Charlotte Department of Transportation

Memorandum

Subject: Rezoning Petition 08-037: Located on the north side of E. Morehead Street
between Queens Road and Bromley Road

REZONING PLAN

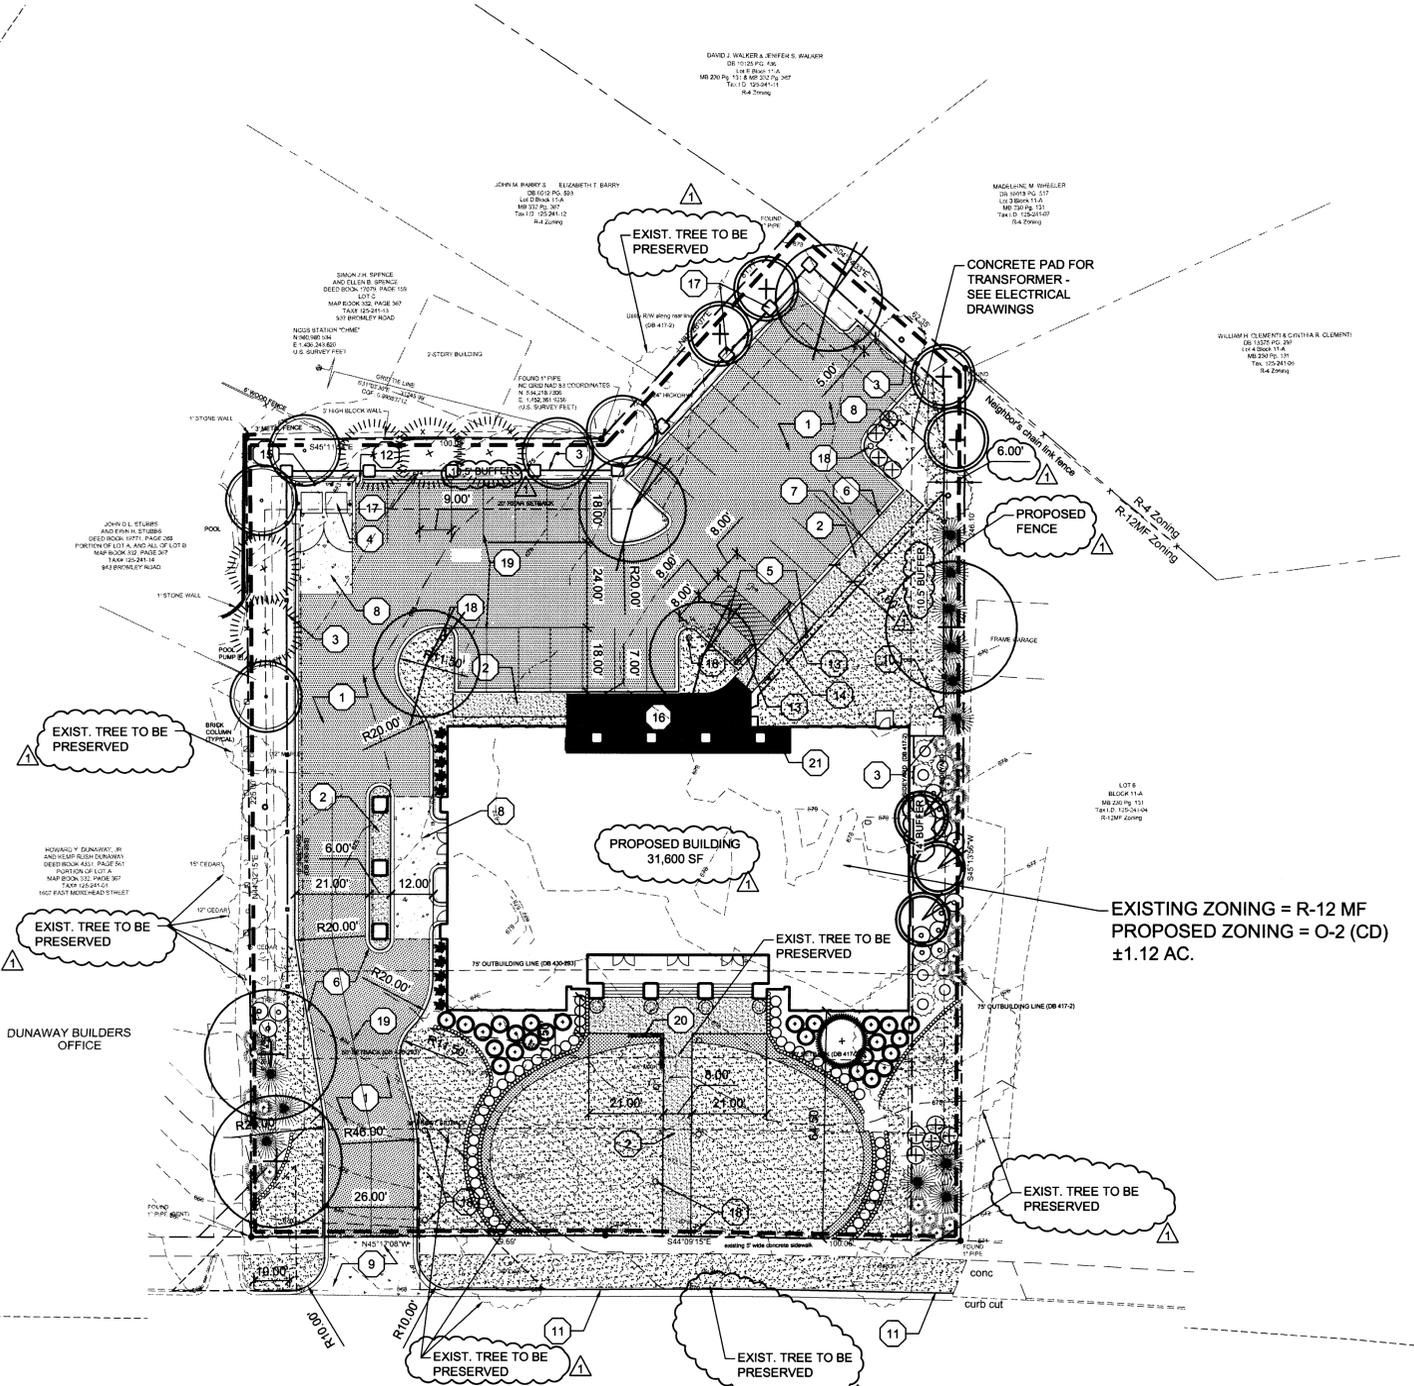
Adequate sight triangles must be reserved at the existing/proposed street entrance(s). Two 10' x 10' and two 10' x 70' sight triangles are required for the entrance(s) to meet requirements, measured from the back of sidewalk and the edge of the driveway. All proposed trees, berms, walls, fences, and/or identification signs must not interfere with sight distance at the entrance(s). Such items should be identified on the site plan.

The proposed driveway connection to Morehead Street will require a driveway permit to be submitted to CDOT and the North Carolina Department of Transportation for review and

approval. The exact driveway location(s) and type/width of the driveway(s) will be determined by CDOT during the driveway permit process. The locations of the driveway(s) shown on the site plan are subject to change in order to align with driveway(s) on the opposite side of the street and comply with City Driveway Regulations and the City Tree Ordinance.
